DECISION DELEGATED TO HEAD OF PLANNING

Application No: H11-0752-22 **Applicant:** Mr I Watson
Proposal: Residential Development - Erection of Dwelling
Location: Adj. Charnwood Delph Road Long Sutton
Terminal Date: 30th September 2022

INDICATIVE SITE PLAN

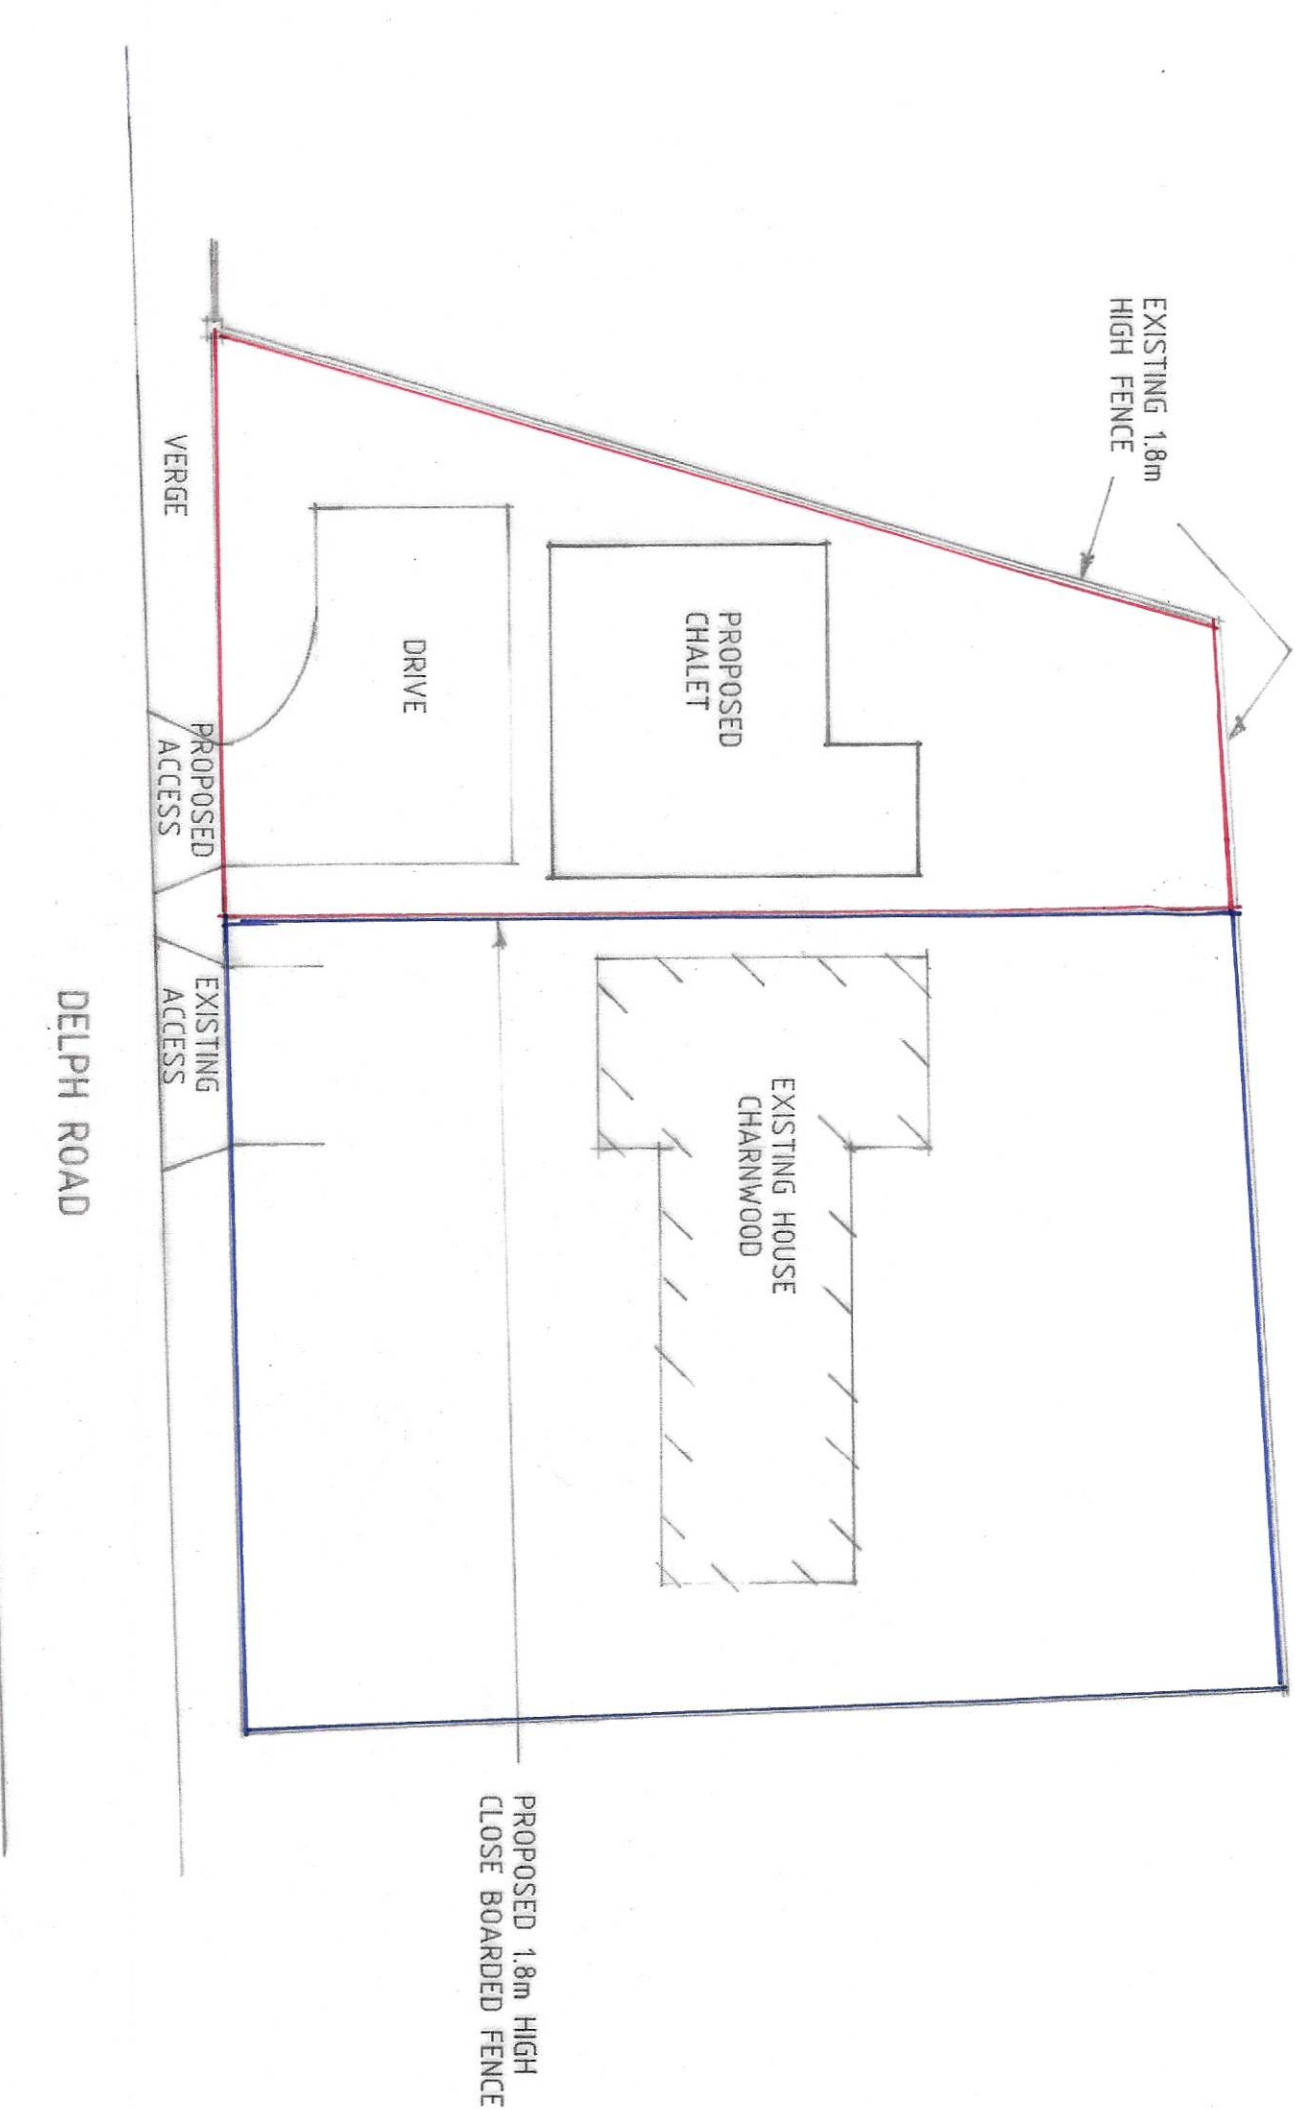
Existing residential development within the immediate vicinity is broadly characterised by houses and bungalows on relatively spacious plots. Generally, there are noticeable gaps between the buildings on those plots. These characteristics, together with trees and other vegetation, combine to give the area a spacious ambience. The proposed dwelling, however, would be sited on a small plot. The proposal would therefore appear cramped in comparison and significantly diminish the spacious characteristics of the area. For those reasons the scheme would be detrimental to the character and appearance of the area. The proposal is therefore considered to be contrary to Policies 2 and 3 of the SELLP.

The plot is restricted in size and is very close to neighbouring dwellings, especially nos. 62 and 64 Station Road to the east and south-east. Also, the finished floor levels of the property would be raised to address flood risk. The general relationship of the proposed dwelling to neighbouring properties is such that the amenity of neighbouring residents would, in all likelihood, be materially harmed by virtue of overlooking, lack of privacy and general overbearing effect/overshadowing.

A new access would be formed onto Delph Road and the existing access would remain in association with "Charnwood". Adequate parking could be provided for both properties. The County Highways Authority has raised no objections on highway safety grounds. The proposal therefore satisfactorily complies with Policies 2, 3 and 36 of the SELLP in terms of parking requirements/highway safety.

In terms of drainage, foul water would be disposed of via the mains sewer and surface water via soakaways, subject to percolation tests. This matter could be addressed by means of a condition if permission was forthcoming.
